RECEIVED
JUL 24 2018
Swauk Valley Conservation Plat File Number LP-17-00007 Compliance Document
Kittitas County CDS

Condition Compliance Document

Swauk Valley Conservation Plat File Number LP-17-00007 Compliance Document

Date: 3-28-18
Scale: 1"=200'
Drawn By: JG
Surveyed By: JG/TB
Checked By: JG
Sheet 1 Of 3
Job Number: 2016-SWK

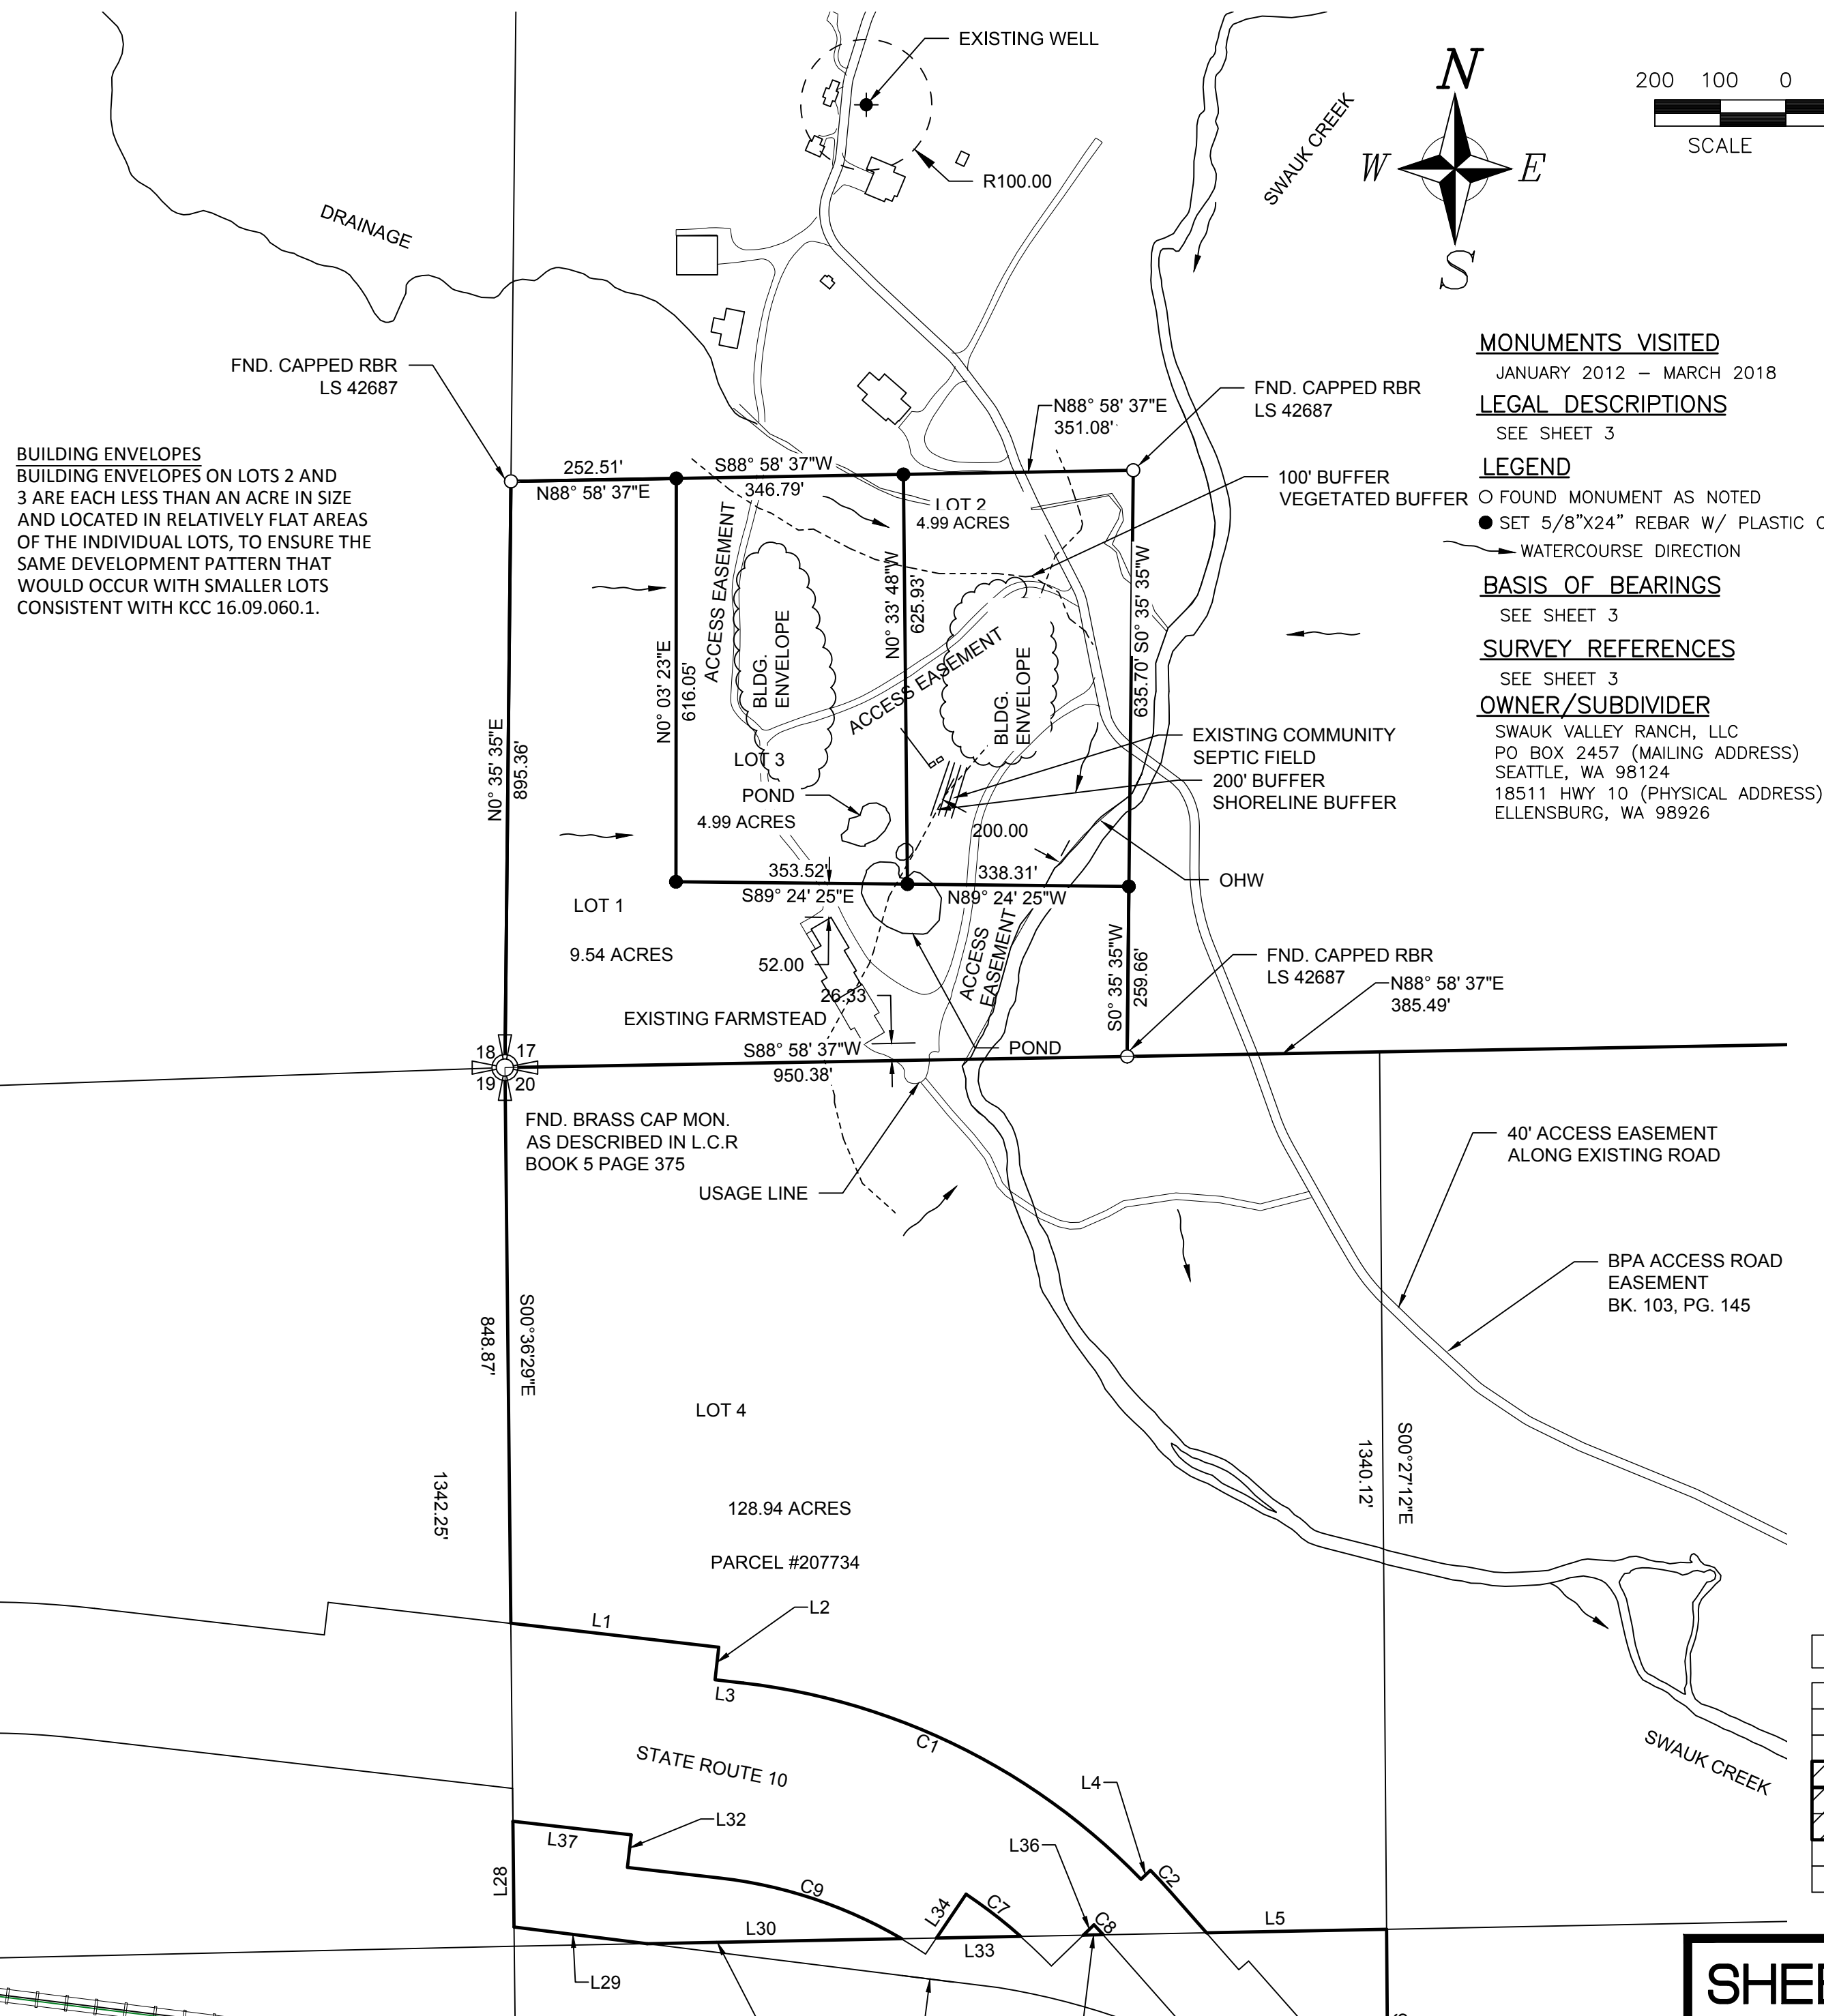
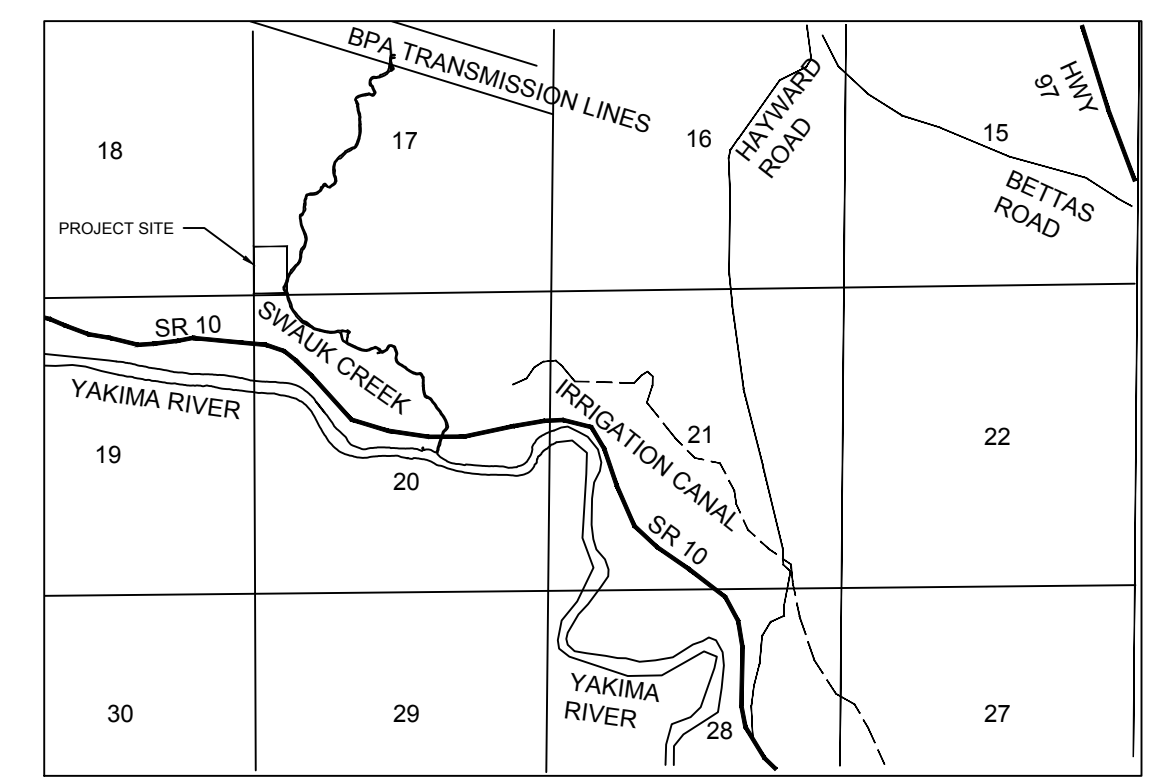
25. The applicant will place the open space tract of 130.72 acres in Open Space for perpetuity and will be designated on the final Mylar	Placement of Lot 4 (Open Space Tract) noted on Sheet 1 of drawings.	OK

26. The use of the open space area will be for passive and active recreational uses as allowed in KCC 16.09.	Noted on Sheet 1 of drawings.	OK
27. The following plat notes shall be recorded on the final mylar drawings:	All plat notes in 27. a-k are noted on the drawings or in notes on Sheet 3.	Items C and D are listed as separate conditions in Findings, shown as one on plat

Sheet 3 Of 3

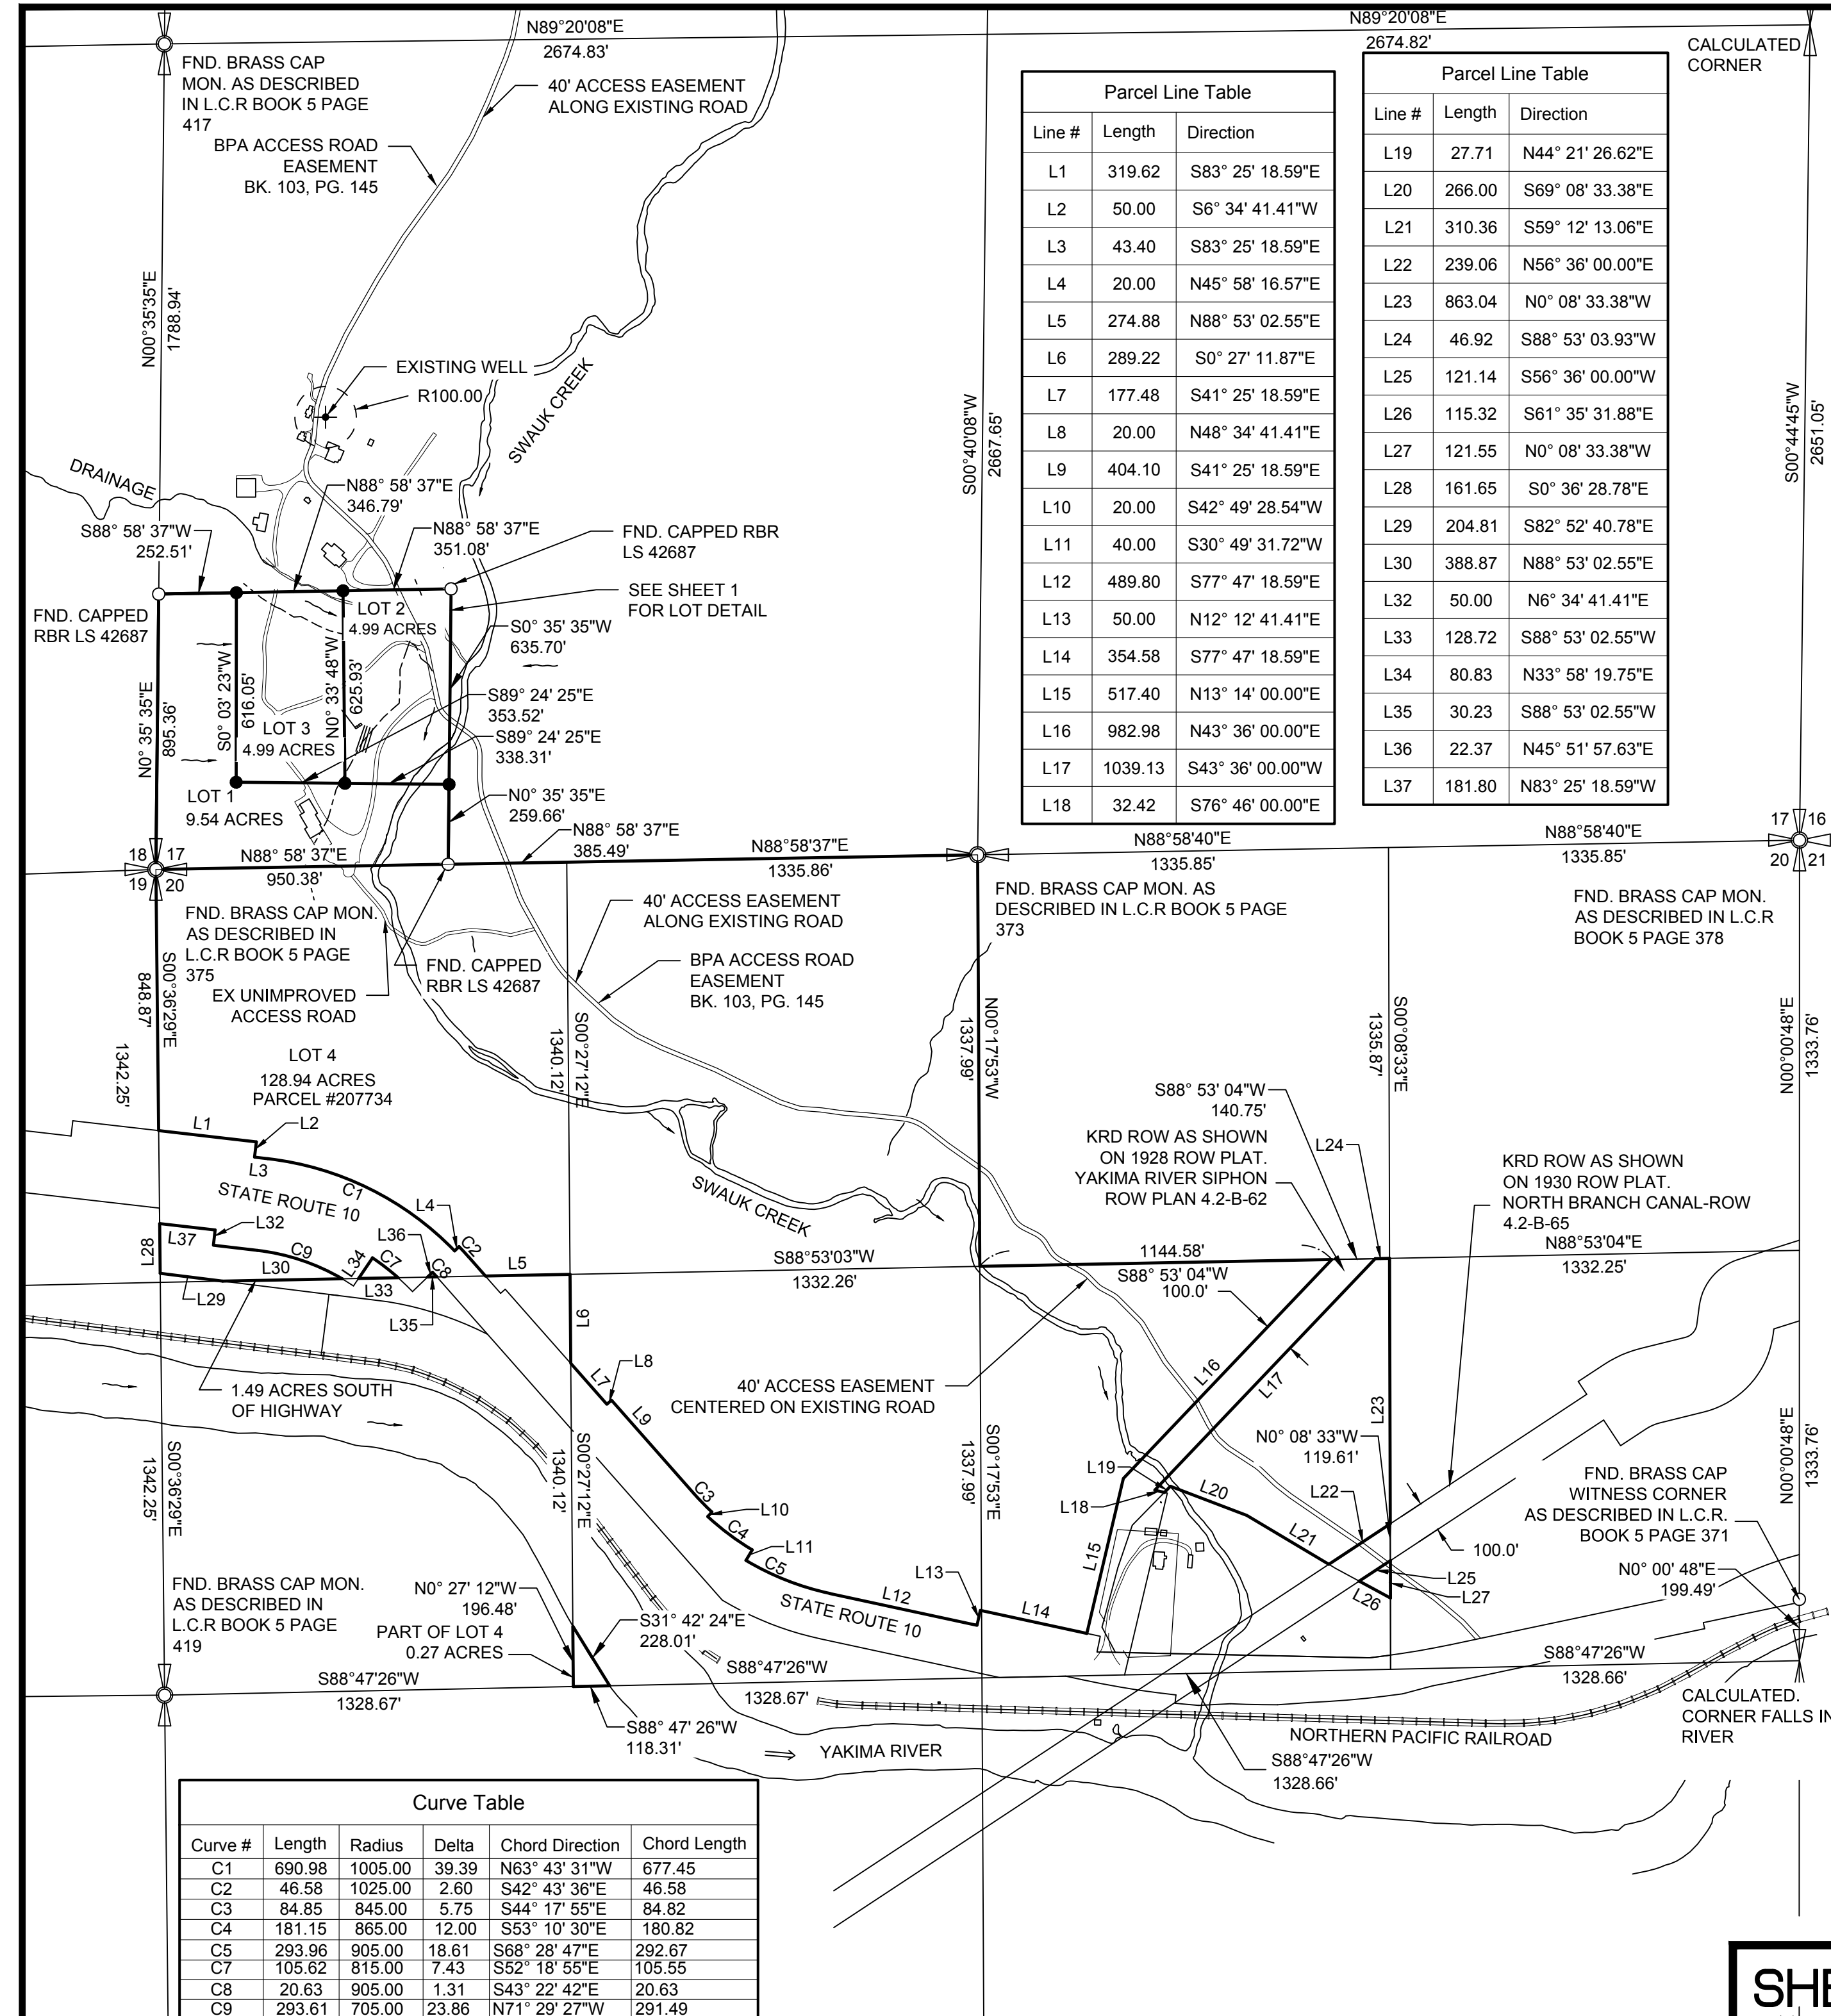
<p>24. The final plat shall include plat notes and appropriate covenants and restrictions ensuring that the open space tract will not be further developed or subdivided in the future.</p>	<p>Note 12 added to Sheet 3 of drawings identifyng open space restrictions on Lot 4.</p>	<p>Actually note 11 on the mylar.</p>
